Ribble Valley Borough Council  
Housing & Development Control

Application no: **3/2024/0028**

Address: **Seedalls Farmhouse Eaves Hall Lane West Bradford Clitheroe BB7 3JG**

Proposal: **Change of use of domestic garage and store to two-bedroom holiday accommodation.**

Seedalls Farm, Leaves Hall Lane, West Bradford, BB7 3JG		19 02 2024
For Mr. & Mrs J Evans		0076
Conversion of garage to holiday let		PL 00 04A
PROPOSED PASSING PLACE

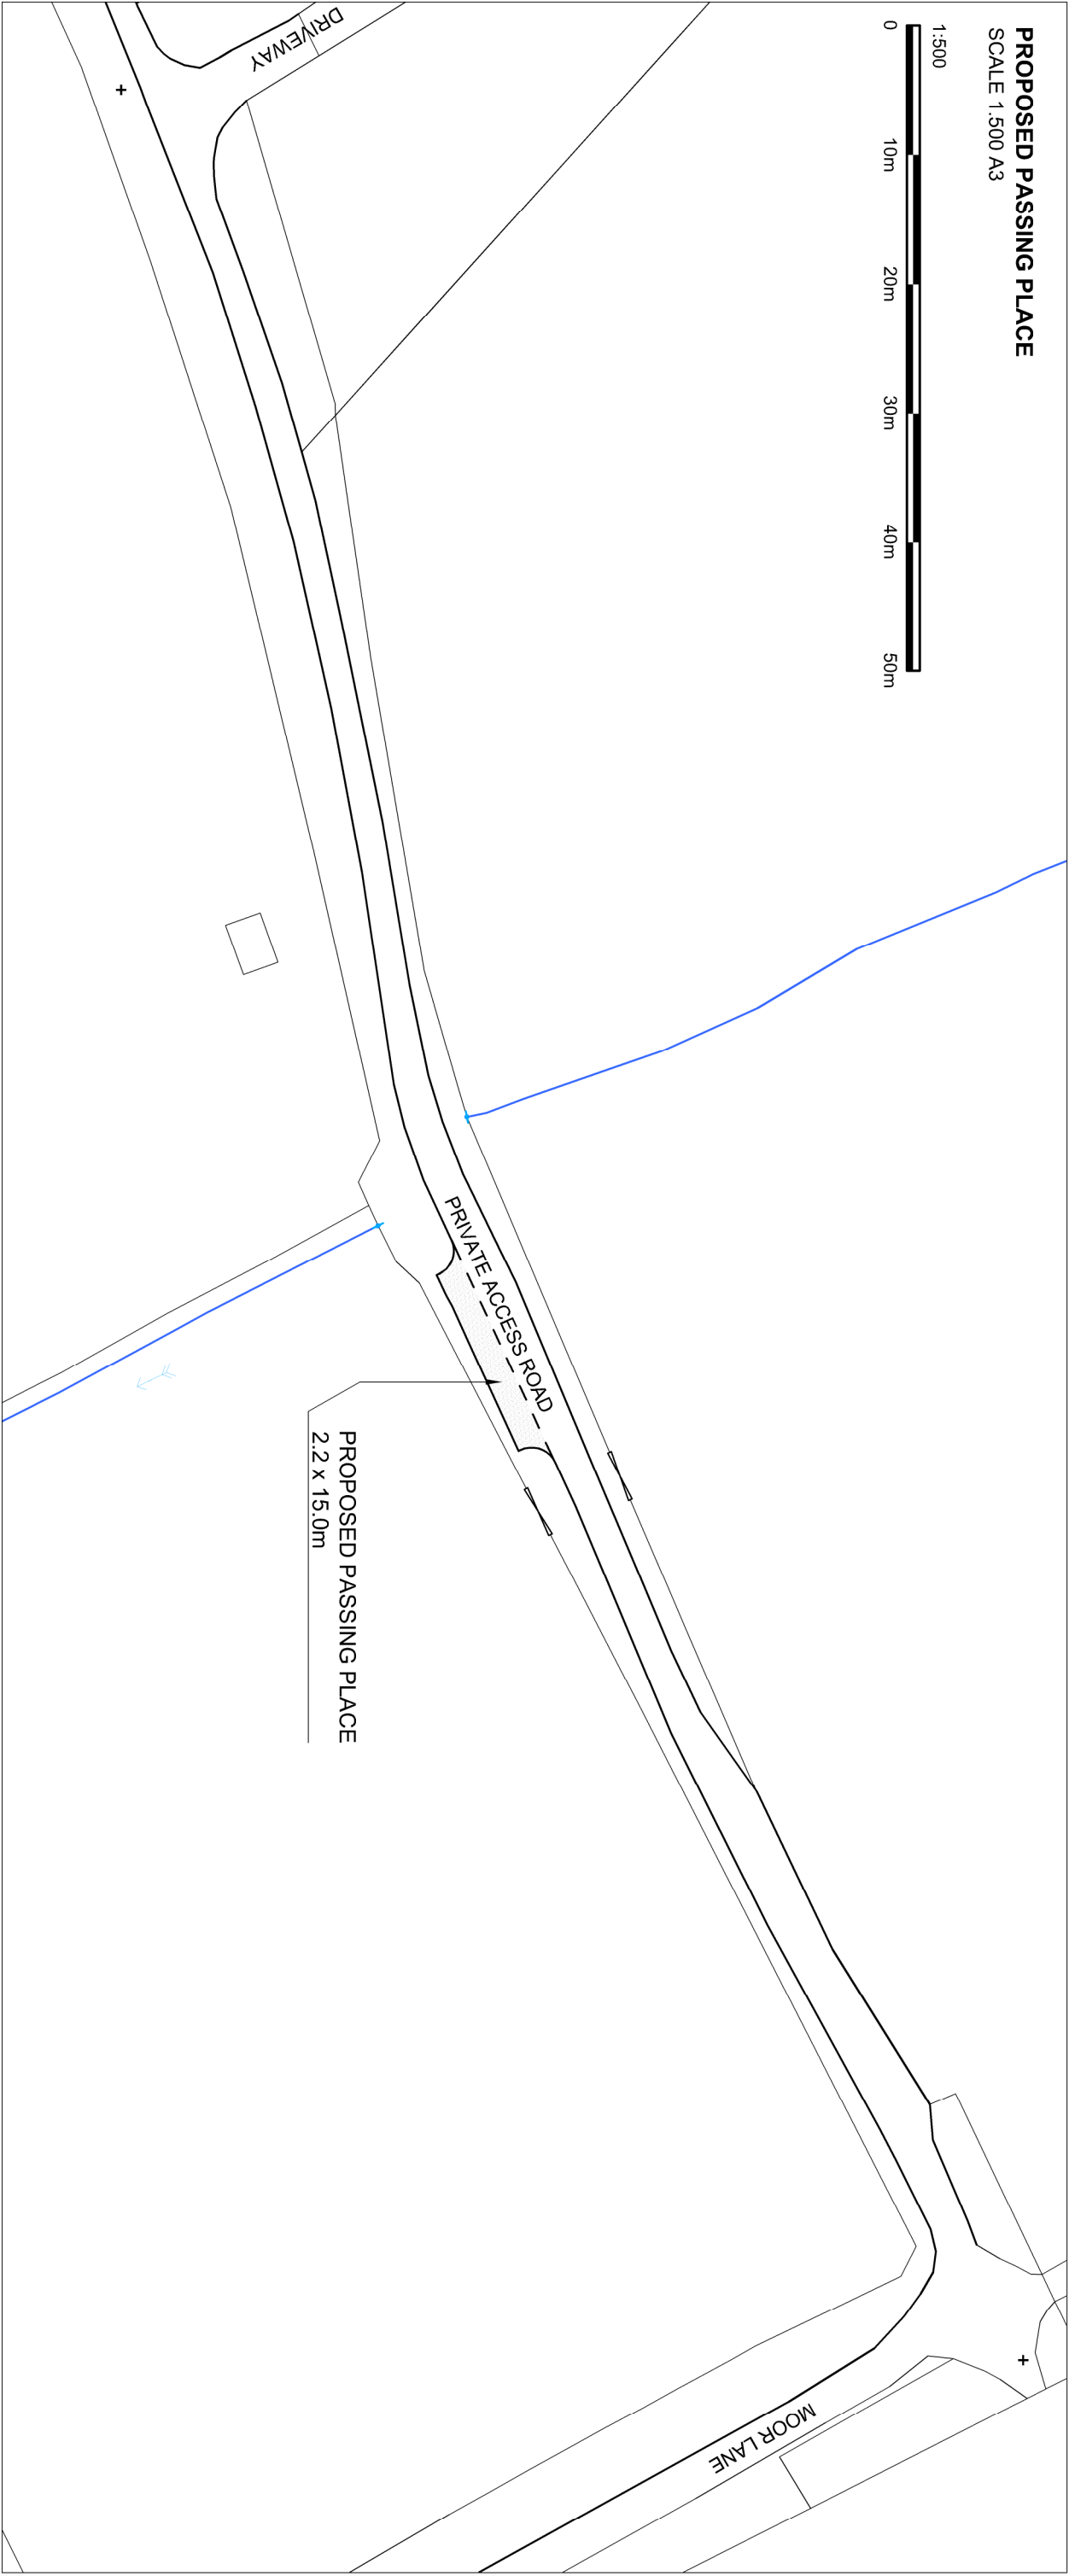
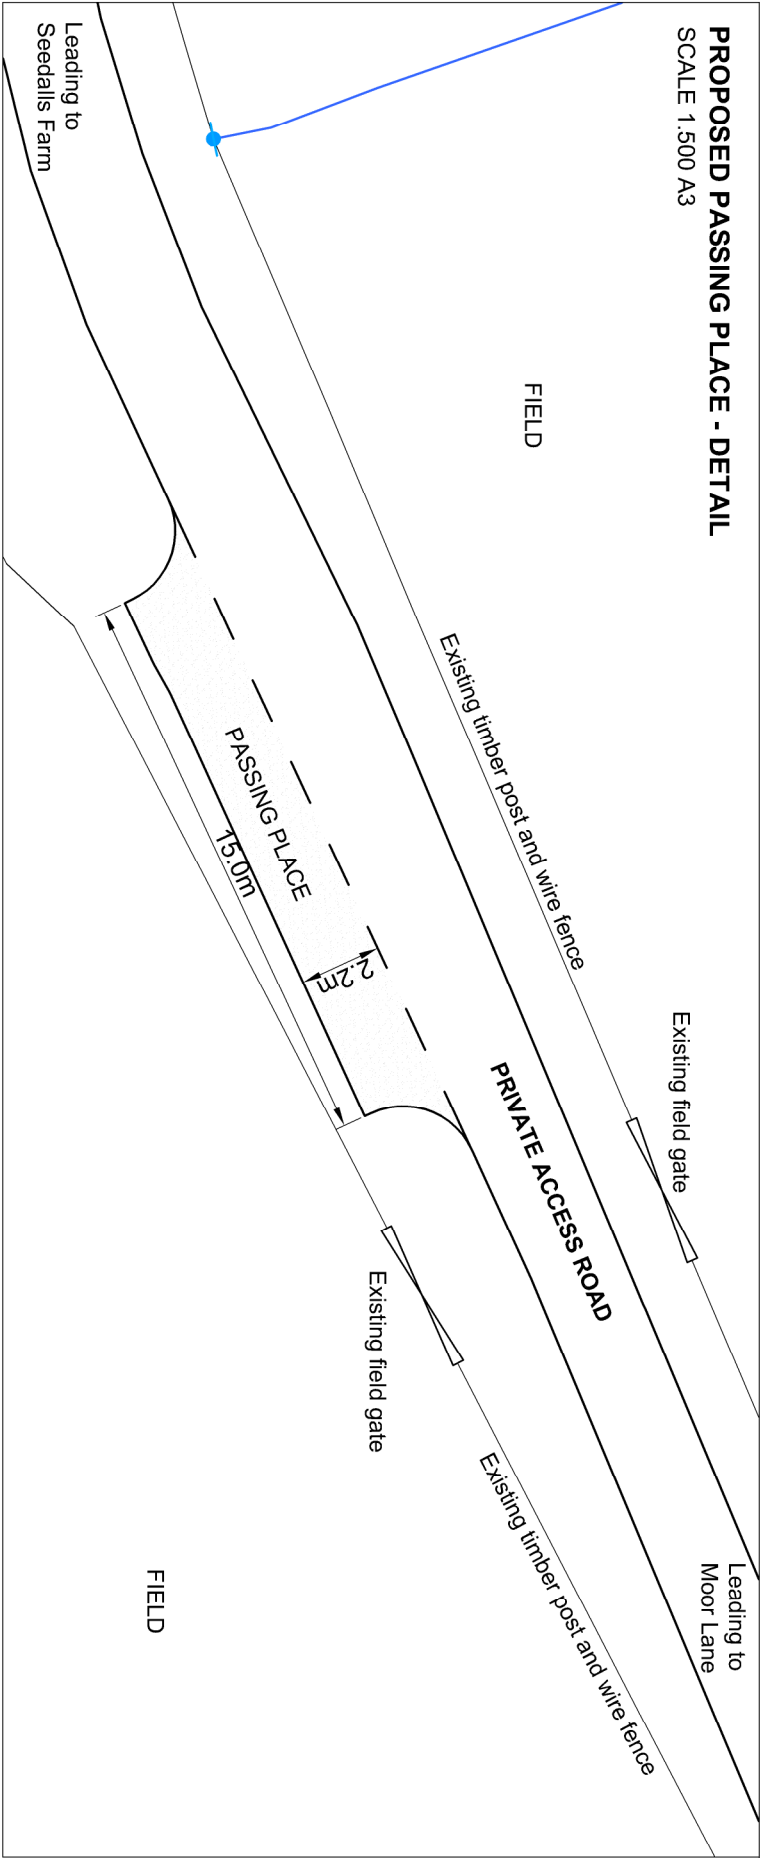
The LHA have further reviewed drawing number PL 00 04A titled "Proposed Passing Place" which shows that the site will provide a minimum of one passing place along the unadopted access track which serves the farm and Public Footpath FP0344007. The LHA welcome the introduction of the passing place which measures 2.2m wide by 15m in length which complies with the LHAs guidance.

2. No part of the development hereby permitted shall be occupied until such time as the access arrangements shown on drawing number PL 00 04A titled "Proposed Passing Place" have been implemented in full.
